Hearings Action Points

Application by Highways England (Case re: TR010036) for an Order Granting Development Consent for the A303 Sparkford to Ilchester Dualling project

Actions arising from the issue specific hearings and open floor hearing held at Yeovil Town Football Club, Huish Park, Lufton Way, Yeovil, Somerset BA22 8YF on Tuesday 14 May and Wednesday 15 May 2019.

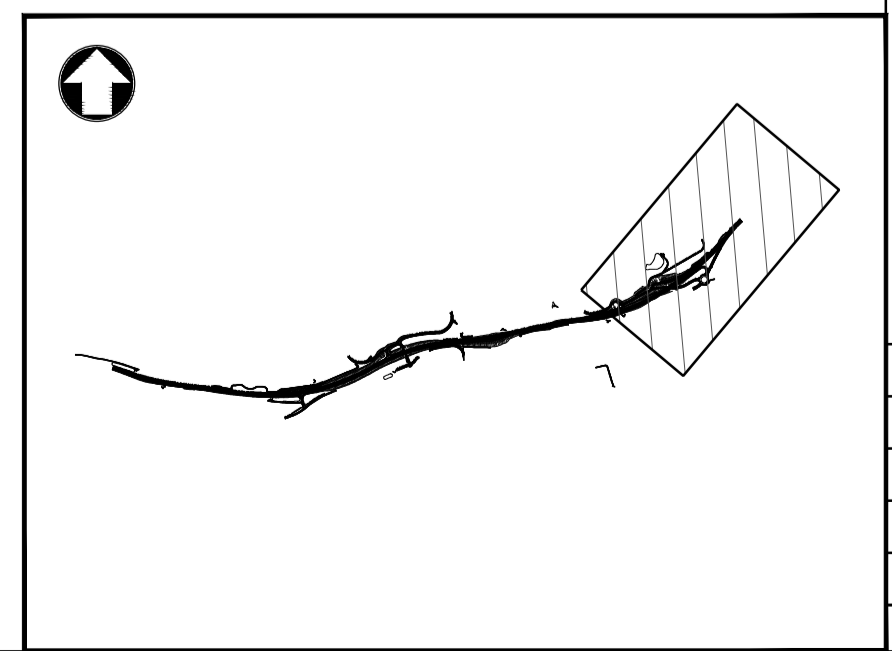
9	Underbridge lighting assessment – Evidence of professional judgement (between D4 and D5) about feasibility of lighting underbridge only, with reference to relevant guidance	Applicant	D7
10	Summary of the traffic management requirements included as part of the proposed developments along Sparkford High Street, including any traffic management plan	South Somerset District Council (SSDC)	D7
11	Note to confirm why it is considered traffic calming/mitigation through local villages is not required.	Applicant	D7
12	OTMP – amend 'should' to 'will' at 2.3.23 also review wording at 2.3.38	Applicant	D7
13	OTMP Communication plan – a) confirm who the working group referred to in paragraph 2.3.23 of the Outline TMP would consist of b) confirm who will determine the detail of the Communication Plan in paragraph 2.3.36 c) review the wording at paragraph 2.3.38	Applicant	D7
14	RNAS Yeovilton – SoCG to be accompanied by plan showing location of CBGM batching plant and other taller equipment such cranes	Applicant	Aim for D7 or asap thereafter
